Kramer Construction, Inc.
5030 Silver Drive, Colorado Springs, CO 80921
phone 719-243-4188
Guttenberg Kennel
14094 E Us Highway 24, Peyton, CO 80831

A-2

Markup Summary

A-2

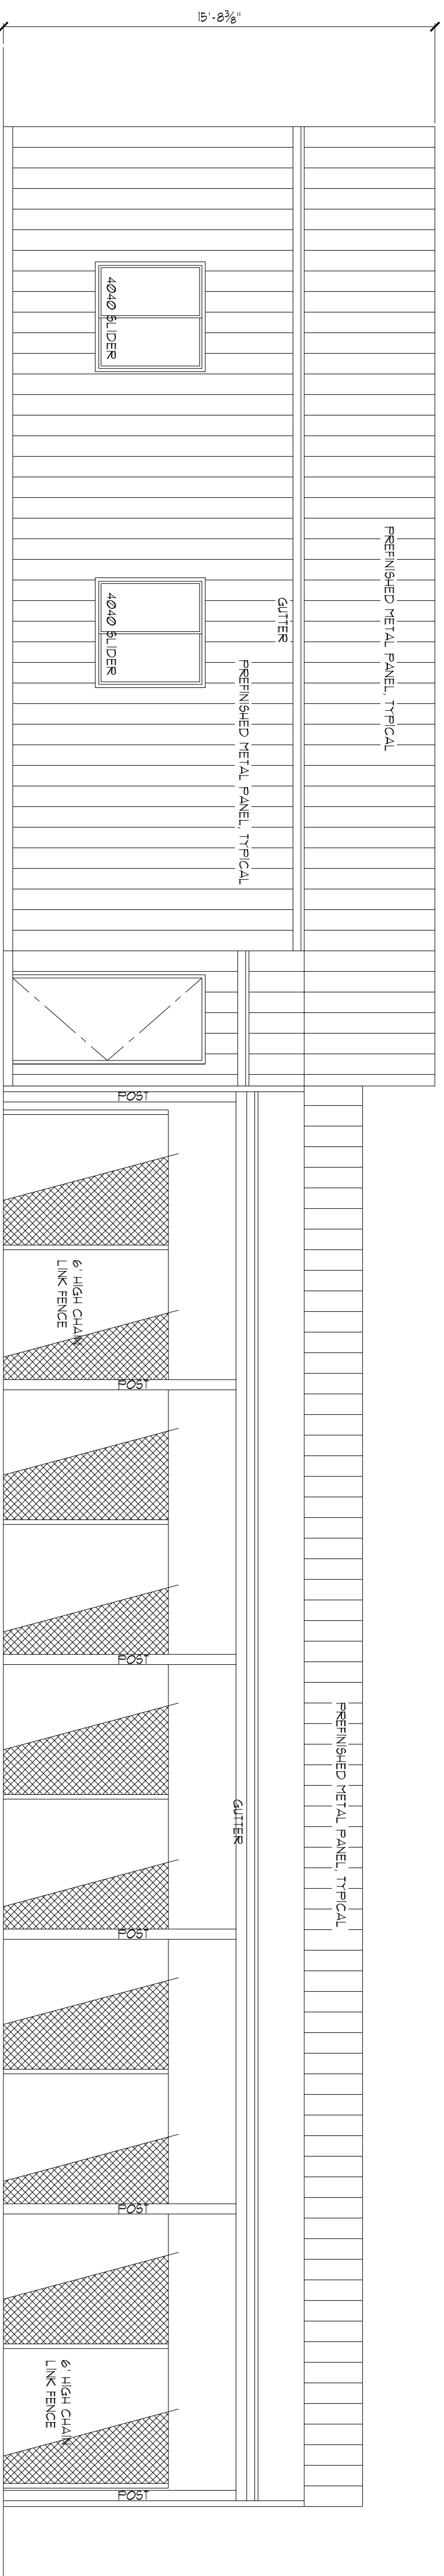
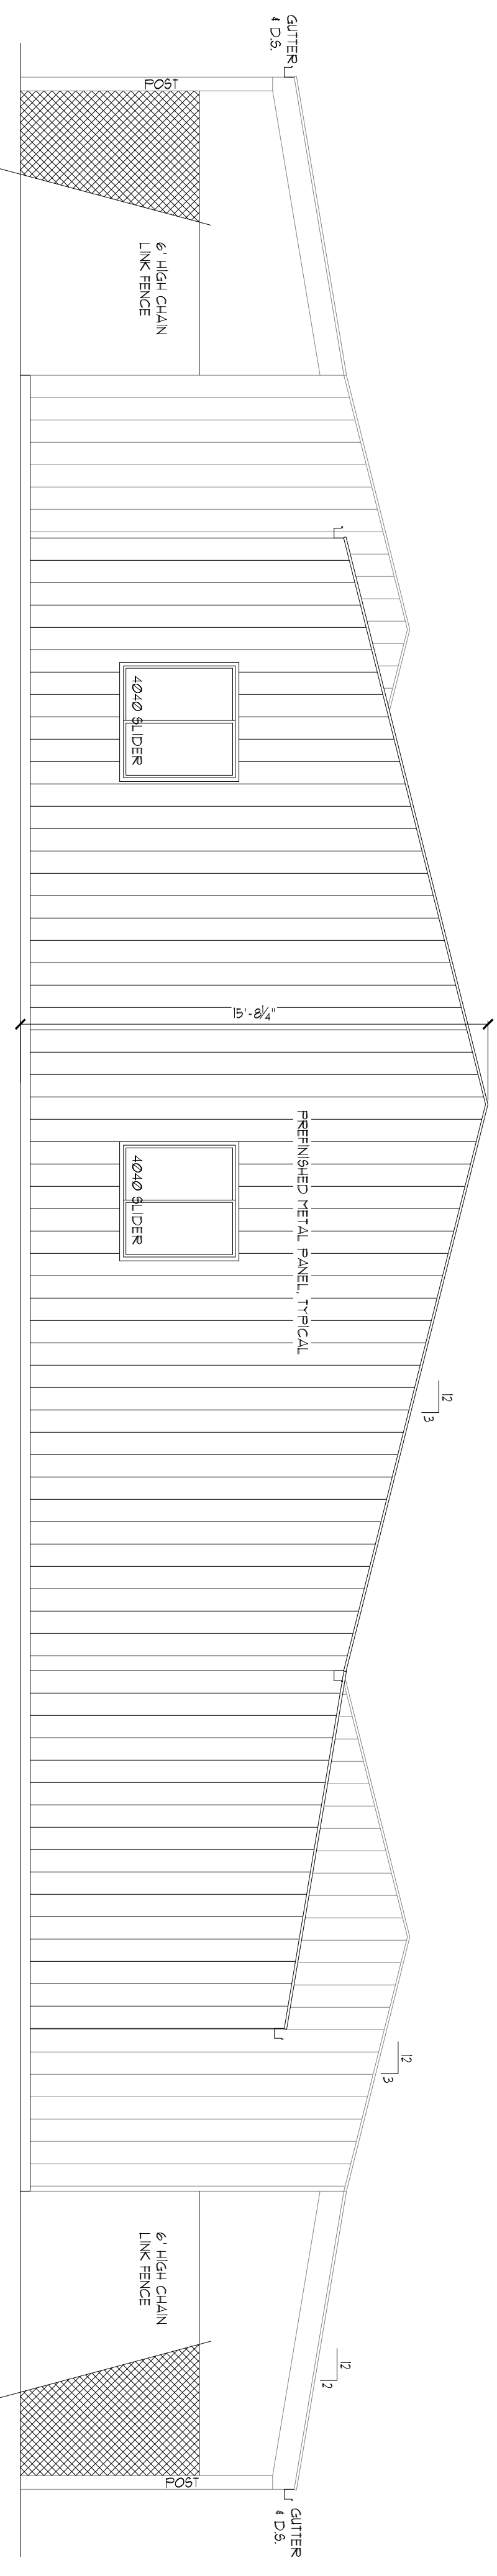
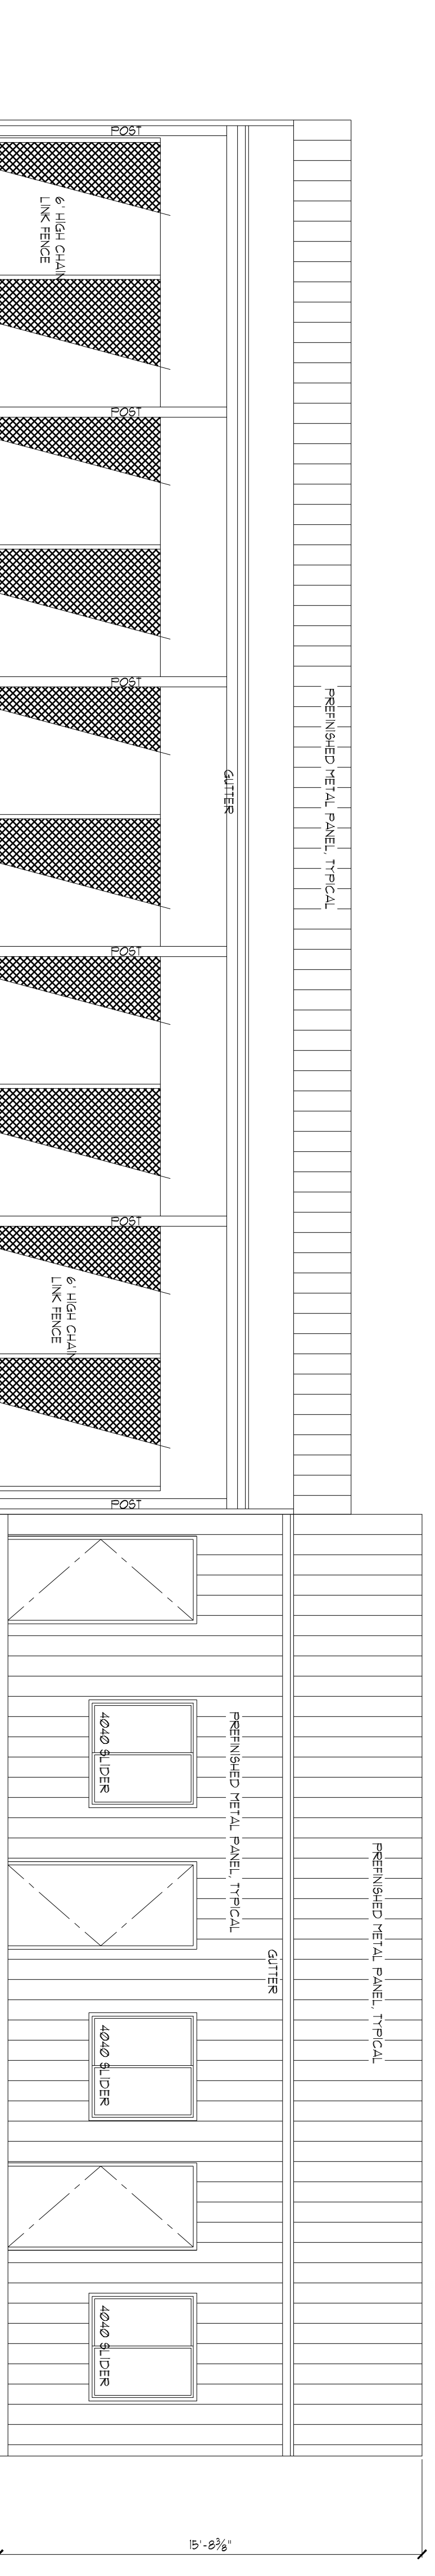
Mark these as
North, South,
East, and
West.
